Our Ref: AWE200083-L01: BCP/bcp
Contact: Dr Brett C. Phillips

22nd February 2021

RESPONSES TO FLOODING SUBMISSIONS, ASPECT INDUSTRIAL ESTATE, KEMPS CREEK, NSW

Figure 38 PMF Flood Extents and Flood Levels - Stage 1 Conditions

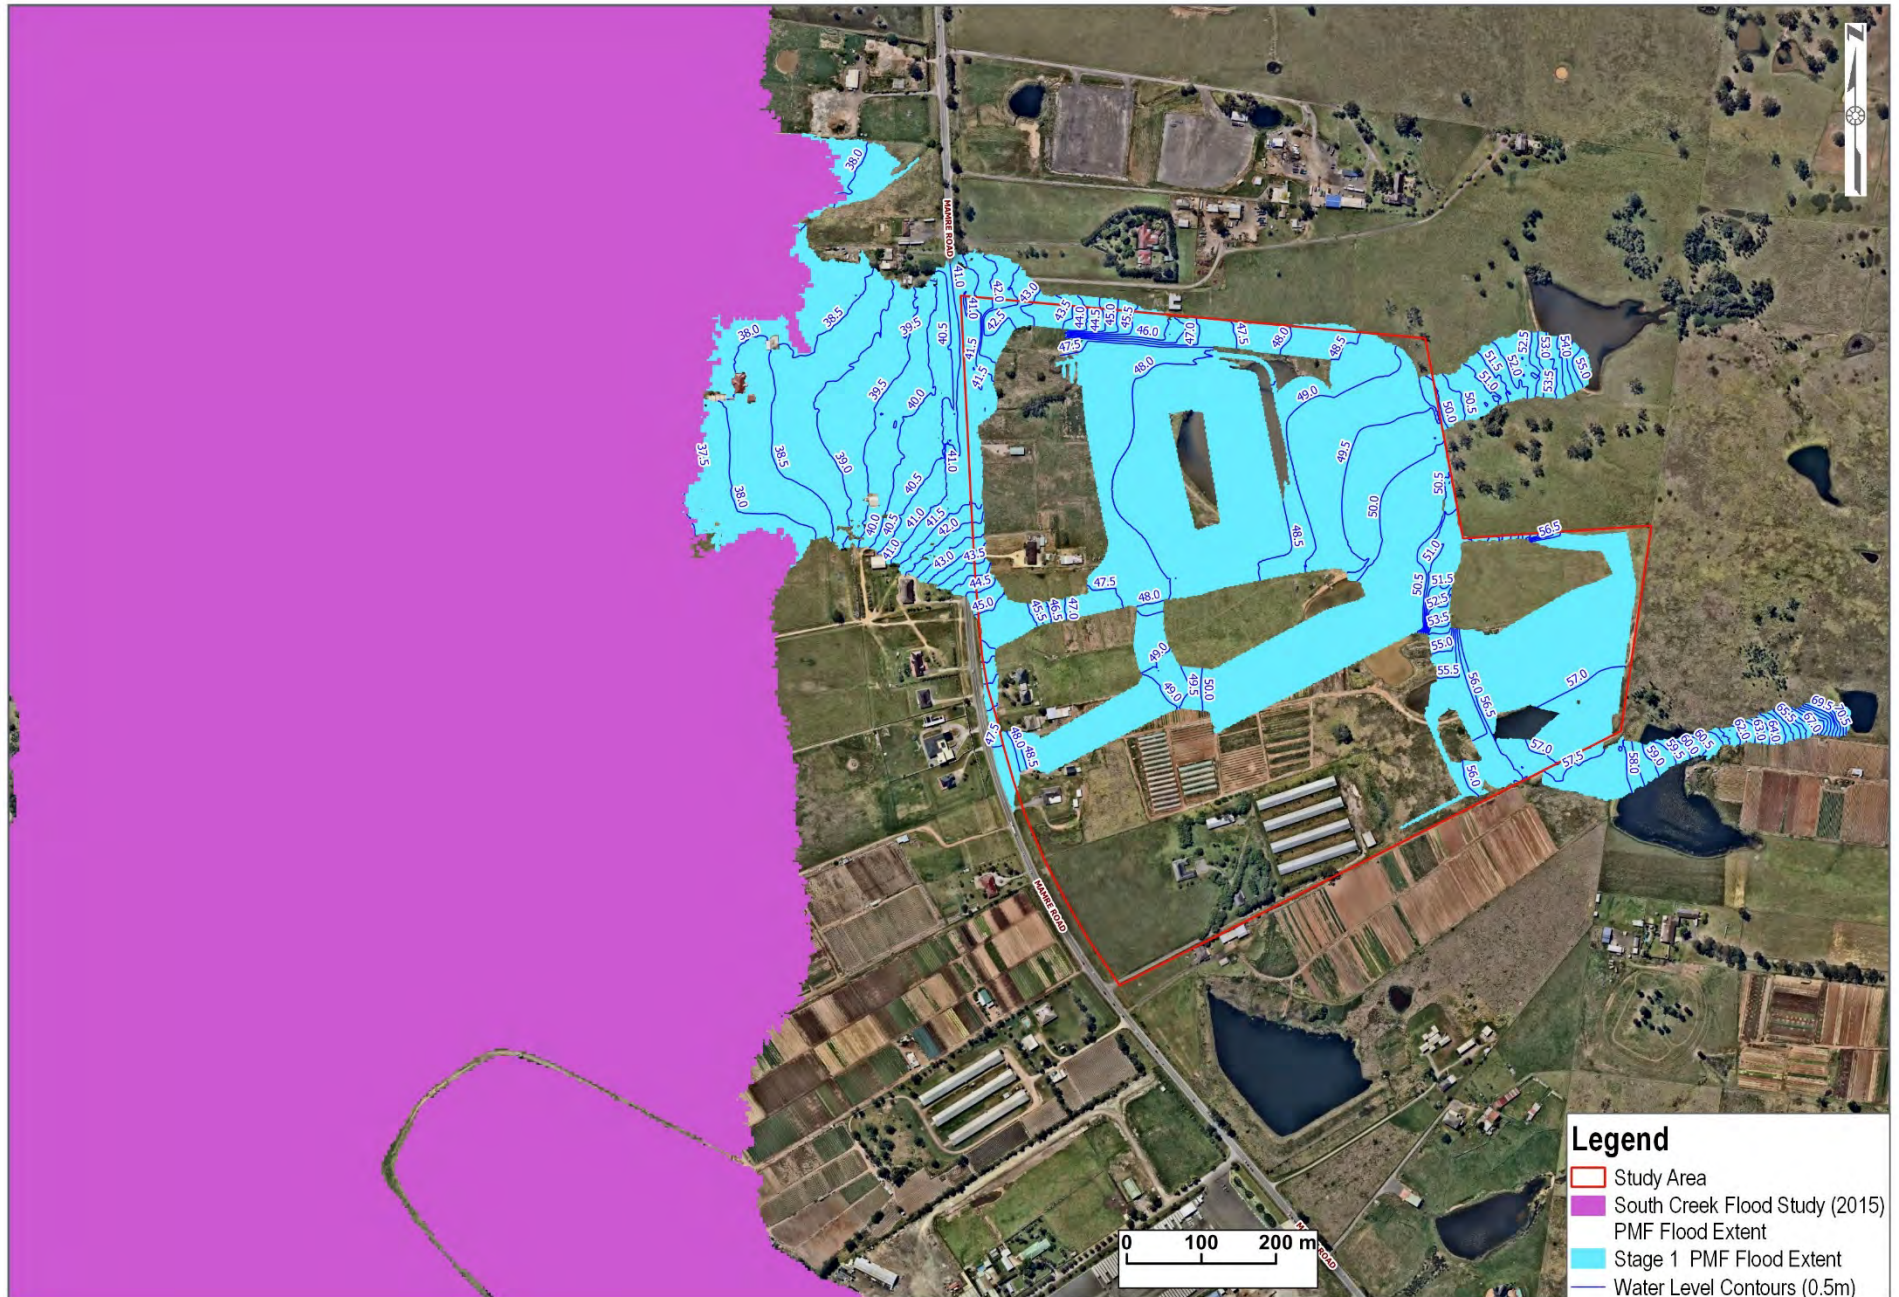
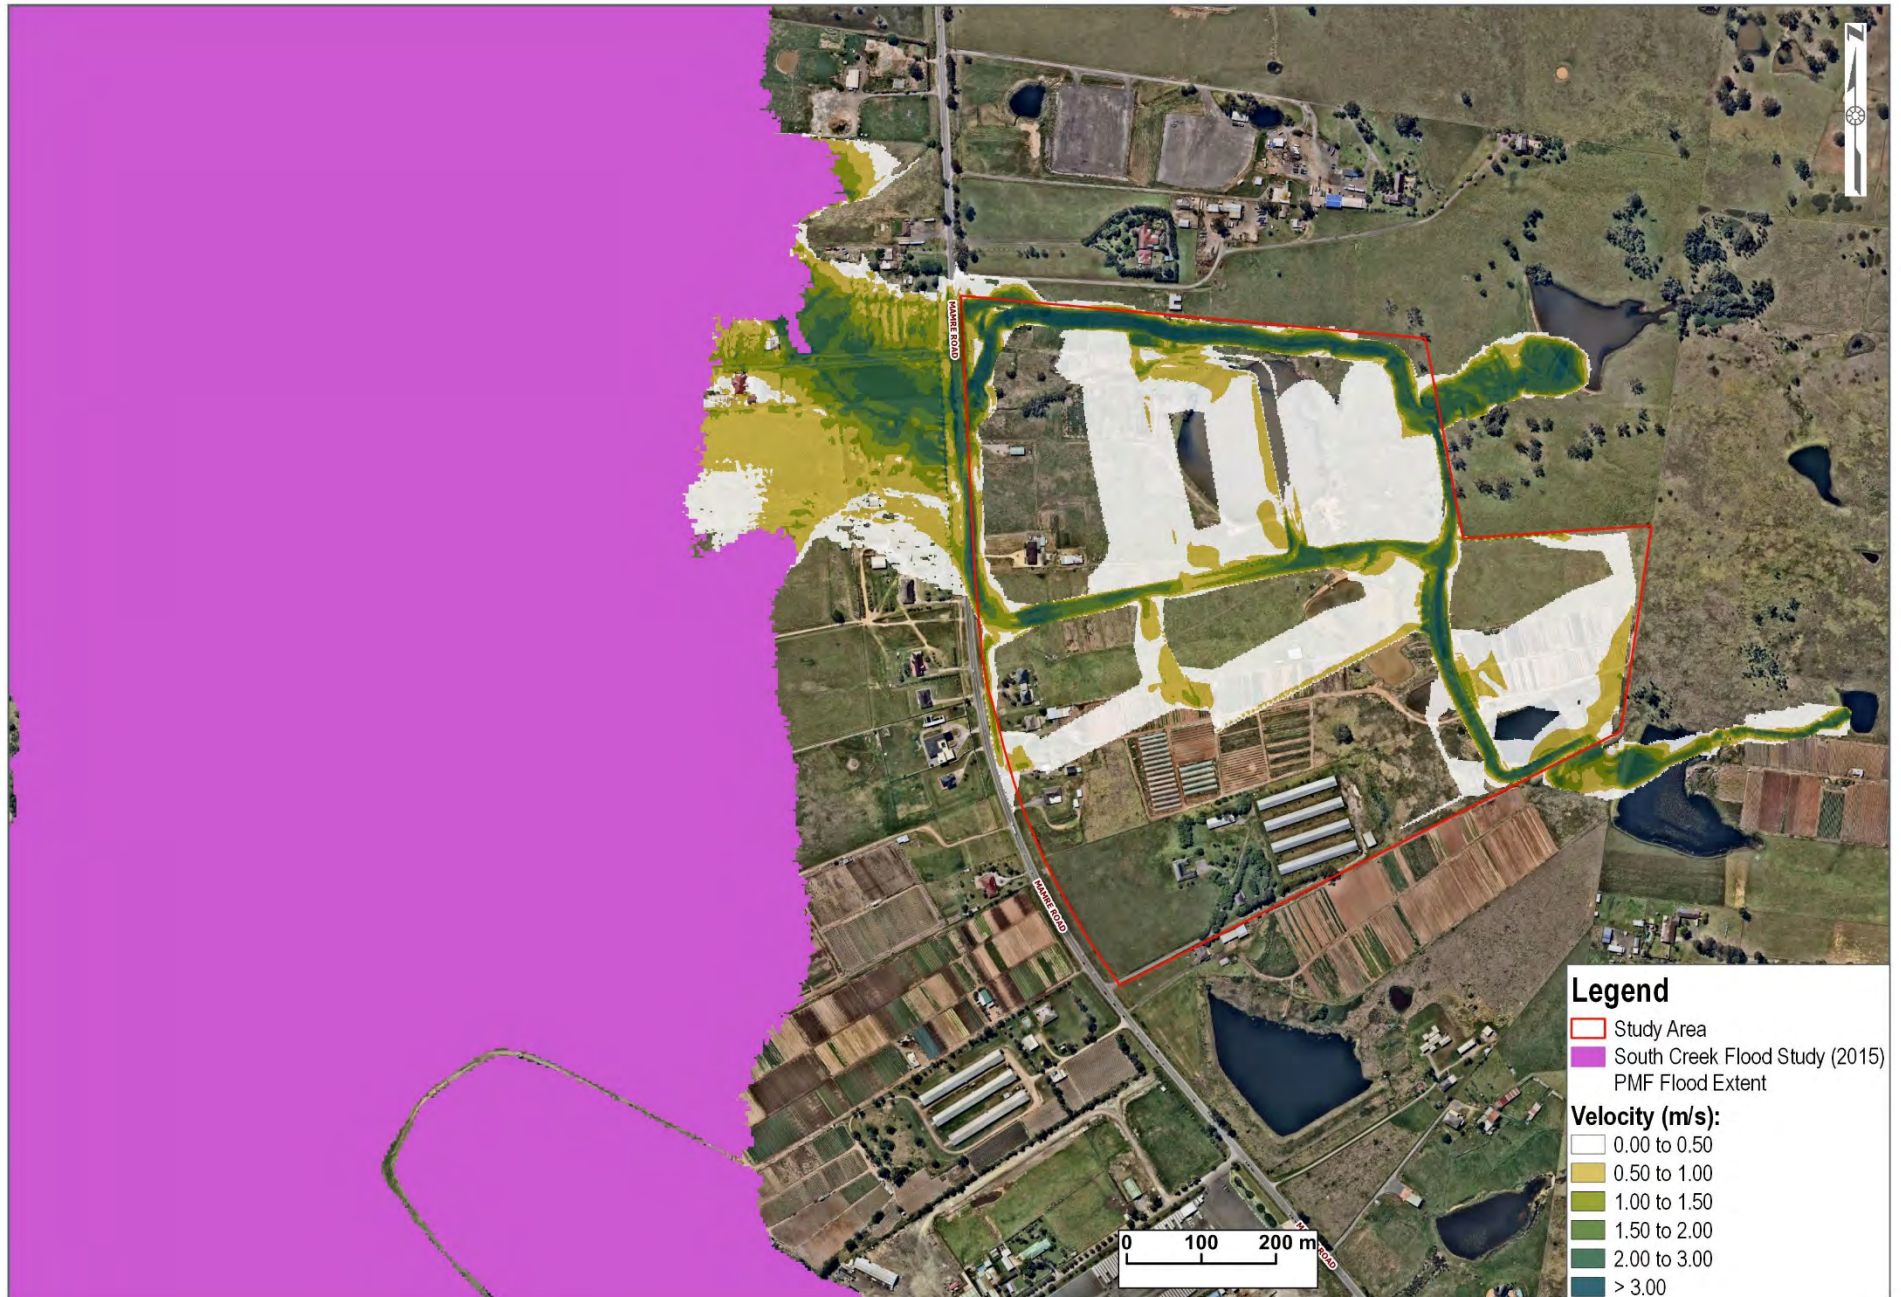
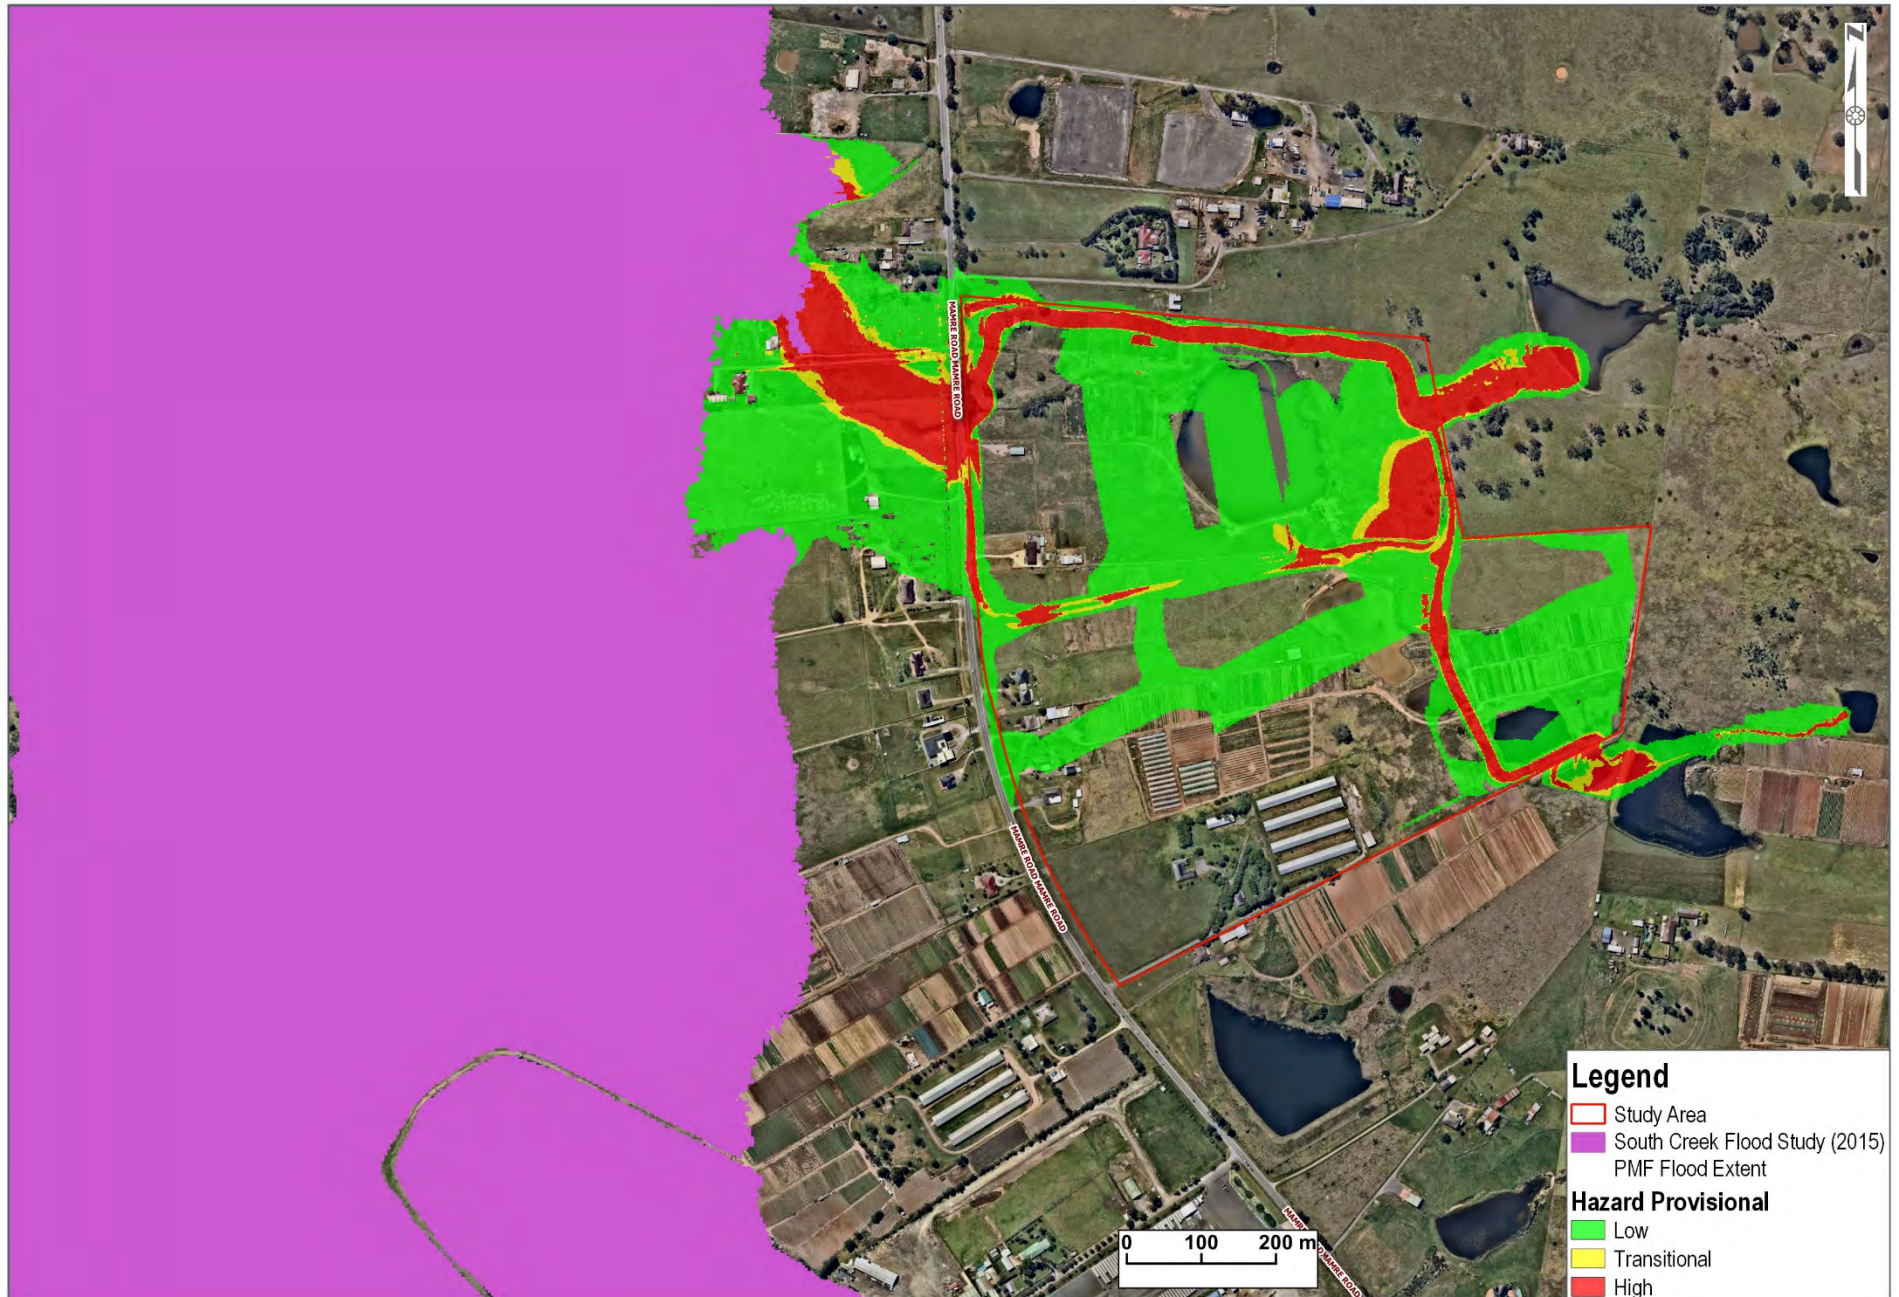
- *The developed scenario maps present local overland flow for Stage 1 which comprises of two industrial lots on the northern part of the site. However, from a flow management perspective, an overland flow study should consider the ultimate developed scenario of the site instead of considering each progressive development independently.*

- *All maps for developed conditions should properly depict the layout of the development, locations of proposed constructed channels and the location of the proposed detention basin.*

The final masterplan has been assessed and the results of the assessment have been incorporated into an updated version of the FIA report.

The updated Figures have been incorporated into an updated version of the FIA report.
